Service Development  
201 S. Jackson Street  
KSC-TR-0426  
Seattle, WA 98104-3856

May 10, 2019

**1. Summary**

**4. The 77<sup>th</sup> Avenue SE Configuration in the Settlement Agreement Does Not Meet Metro’s Operational and Spatial Requirements.**

**Figure 6: Improved Service Configuration**

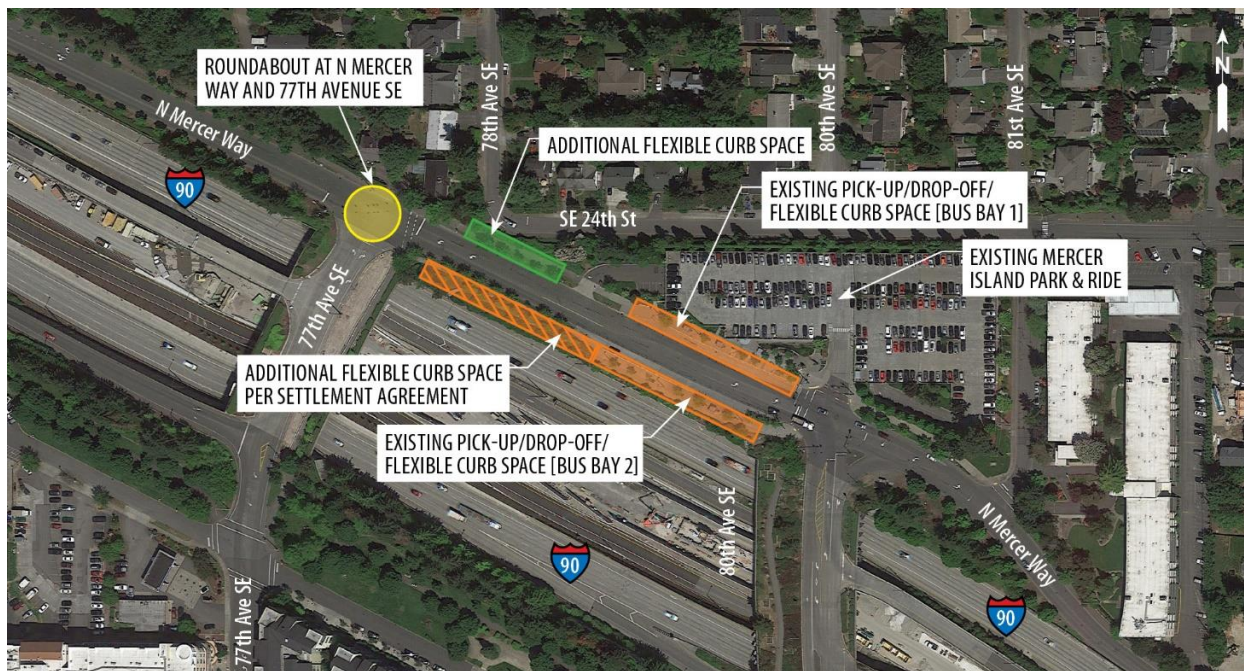
4.2 The Elimination of Layover, Pick-up, and Drop-off on the North Side of North Mercer Way Is Unworkable.

In Section 4.2 (a) and Section 4.3 (a), the Settlement Agreement would limit all bus drop-off and pick-up, and all layover areas (other than for local Mercer Island buses, as indicated in 4.2 (a)) to the south side of North Mercer Way.<sup>2</sup> These restrictions would limit the amount of service that Metro can provide and would complicate operations for customers traveling between Eastside communities and Mercer Island. Metro and Sound Transit buses currently pick-up and drop-off on both sides of North Mercer Way, so these restrictions would significantly reduce space for boarding and deboarding compared to current conditions.

Perhaps more significantly, layover on the north side of North Mercer Way would not function without the active bus bay on the north side of North Mercer Way; without that bay, buses would have to circle back through the Mercer Island town center along 27<sup>th</sup> Street after dropping off passengers on the south side of North Mercer Way. The result would be longer trips for passengers, increased operational costs, and additional impact to the Mercer Island town center (more buses traveling along 27<sup>th</sup> Street). To meet its operational needs, Metro will require active pick-up/drop-off and layover on *both* sides of North Mercer Way as outlined in the Improved or Optimal Service Configuration in the Mercer Island Transit Operational and Configuration Study.

1. Allow layover at all times of day, without a 15-minute or other time limit.
2. Allow pick-up, drop-off, and layover on both sides of North Mercer Way as outlined in the Improved or Optimal Service Configuration in the Mercer Island Transit Operational and Configuration Study.

Figure 7: Optimal Service Configuration

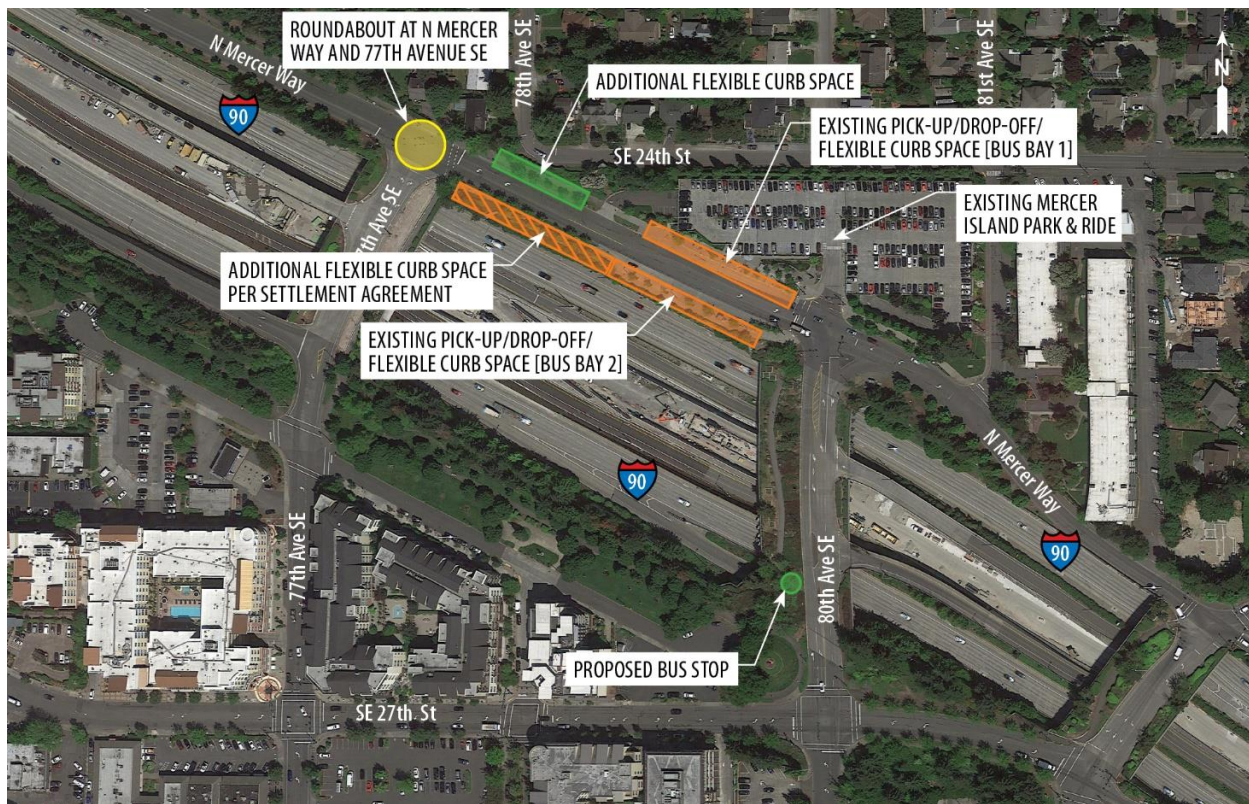
Under Section 4.3 (b) of the Settlement Agreement, bus layovers would be limited to no more than 15 minutes, and then only during the afternoon peak period (3:30pm - 7:00pm). However, Metro will need layover throughout the day and not limited in duration to provide any service to Mercer Island Station. First, Metro cannot legally limit bus layover duration because of labor contract requirements mandating operator rest periods. (However, typical layover times range from approximately 10-15 minutes, meaning that in practice the majority of layover would meet the intent of Section 4.3(b)). In addition, longer layover increases Metro's operating costs, so the agency continuously strives to *limit* layover duration rather than extend it.

Second, limiting layover to the afternoon peak period would prevent Metro from providing needed morning peak service to Mercer Island, or all-day on-island service. Therefore, to meet Metro's operational needs, layover must be allowed throughout the day, and must not be limited in duration. Finally, Metro buses do not idle during layover, so bus emissions and noise should not be a concern.

Specifically, Metro requires the 77<sup>th</sup> Avenue SE Configuration be implemented with the following refinements:
